WEST SUSSEX COUNTY COUNCIL CONSULTATION

TO:	Arun District Council FAO: Simon Davis
FROM:	WSCC - Highways Authority
DATE:	20 November 2019
LOCATION:	1-2 The Parade, Argyle Road, Bognor Regis, PO21 1DT
SUBJECT:	BR/286/19/PL Side & roof extension to existing mixed use building to provide retail storage, cycle, refuse/recycling store at ground level. Alterations to existing first floor 1 bedroom flat with an additional 1 bedroom studio & 1no. proposed studio flat to roof extension - Resubmission of BR/125/19/PL.
DATE OF SITE VISIT:	N/A
RECOMMENDATION:	Advice
S106 CONTRIBUTION TOTAL:	N/A

project title	1-2 Argyle Road, Bognor Regis
drawing title	Proposed Location & Plan

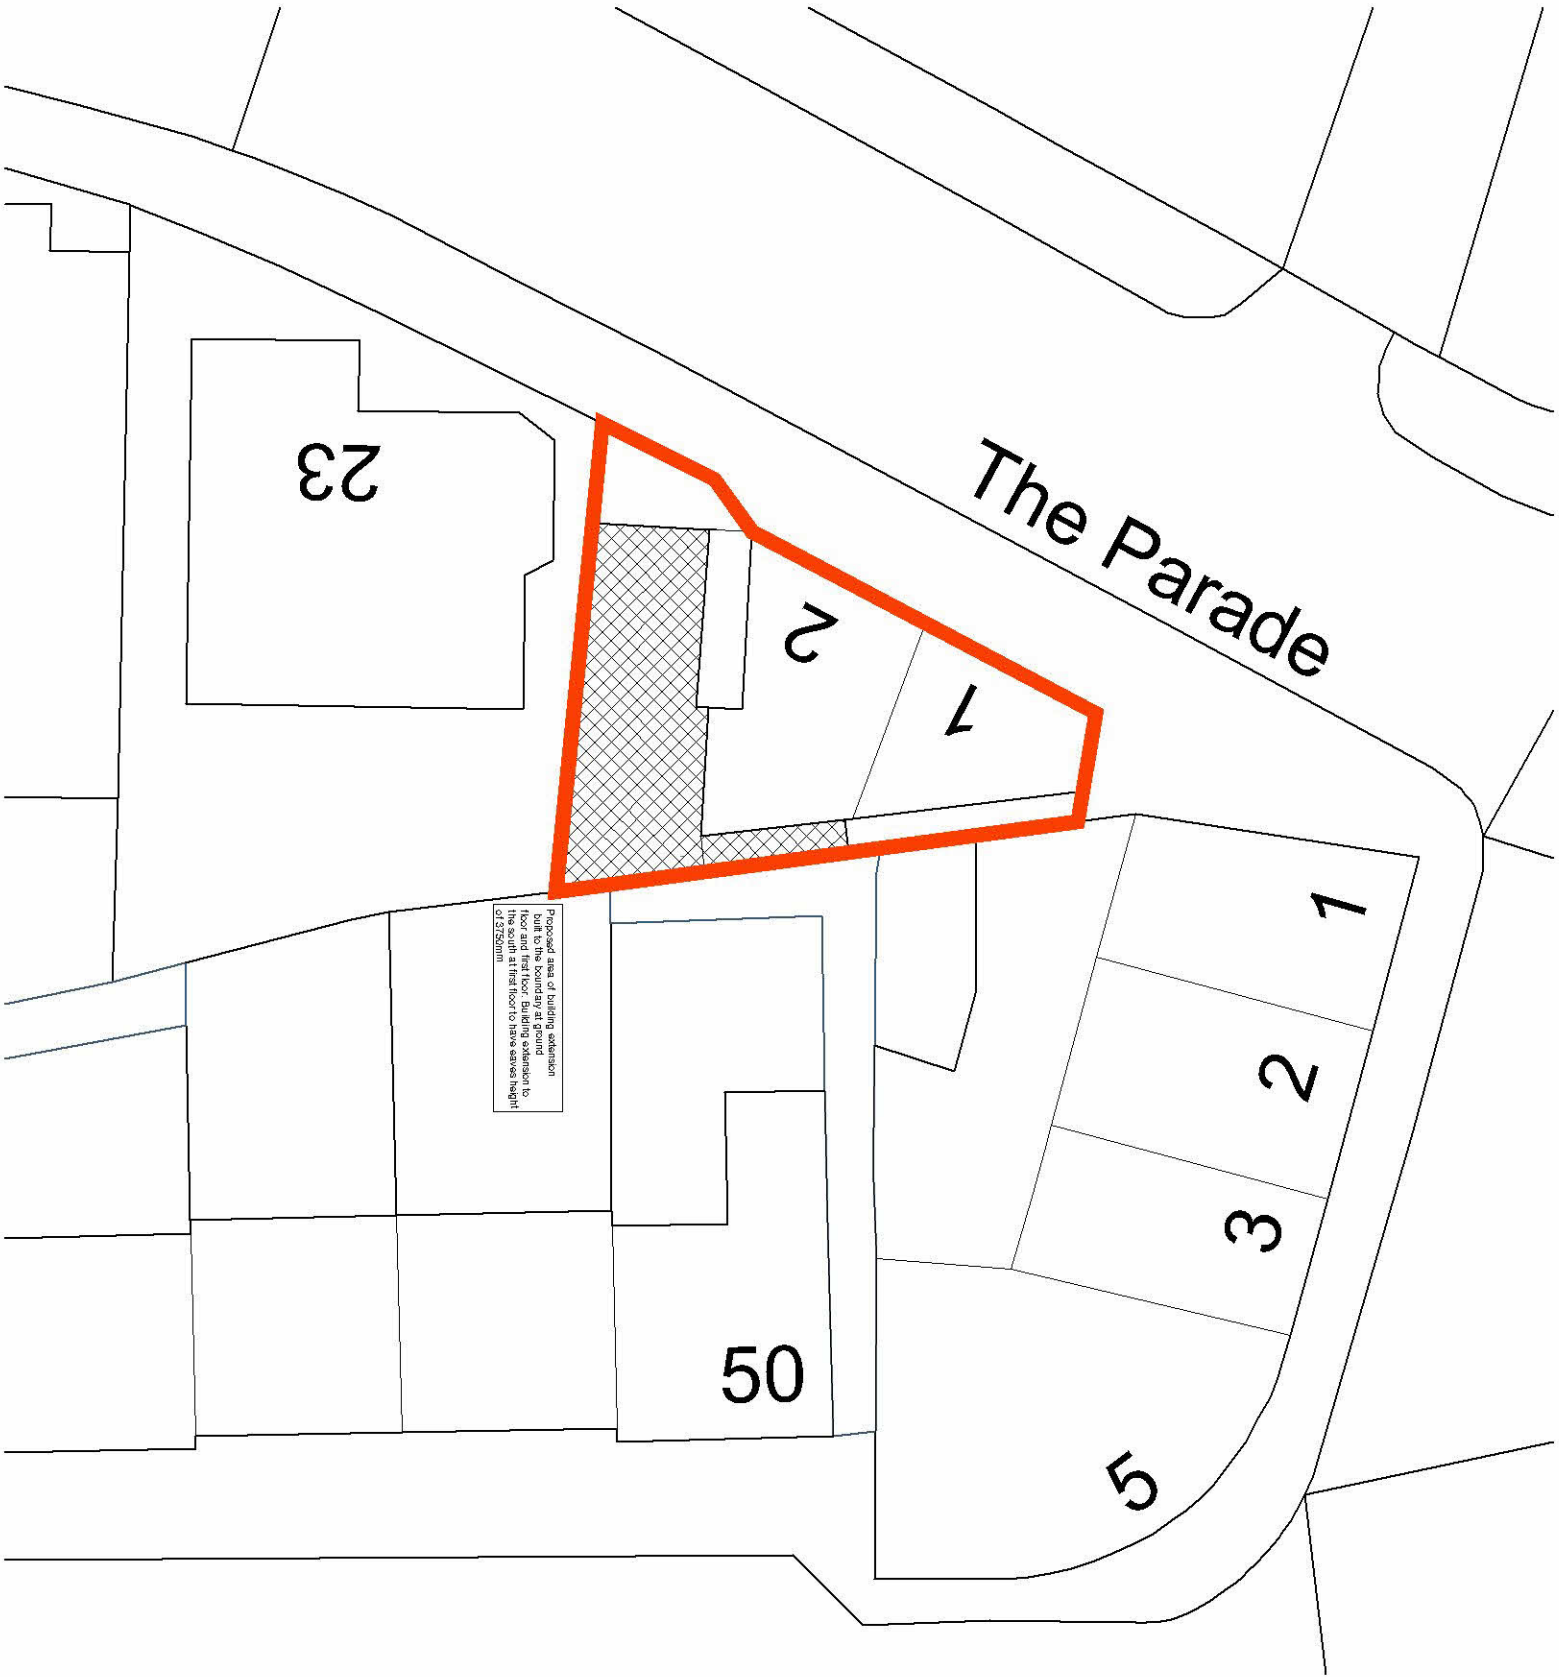
1 existing car parking space will be retained for this development, within an under-croft parking area. The parking area is of sufficient size to allow for 1 parking space that meets the Manual for Streets (MfS) minimum specifications for single car bays of 2.4m x 4.8m. It is unclear whether the proposed parking space will be allocated.

Cycle parking has been demonstrated in the plans. WSCC parking standards require 1 cycle parking space per 1-2 bedroom dwelling, which has been shown in the plans. The inclusion of cycle parking helps promote the use of sustainable alternative modes of transport to the private car.

No part of the development shall be first occupied until covered and secure cycle parking spaces have been provided in accordance with plans and details to be submitted to and approved by the Local Planning Authority.

No part of the development shall be first occupied until the car parking has been constructed in accordance with the approved site plan. These spaces shall thereafter be retained at all times for their designated purpose.
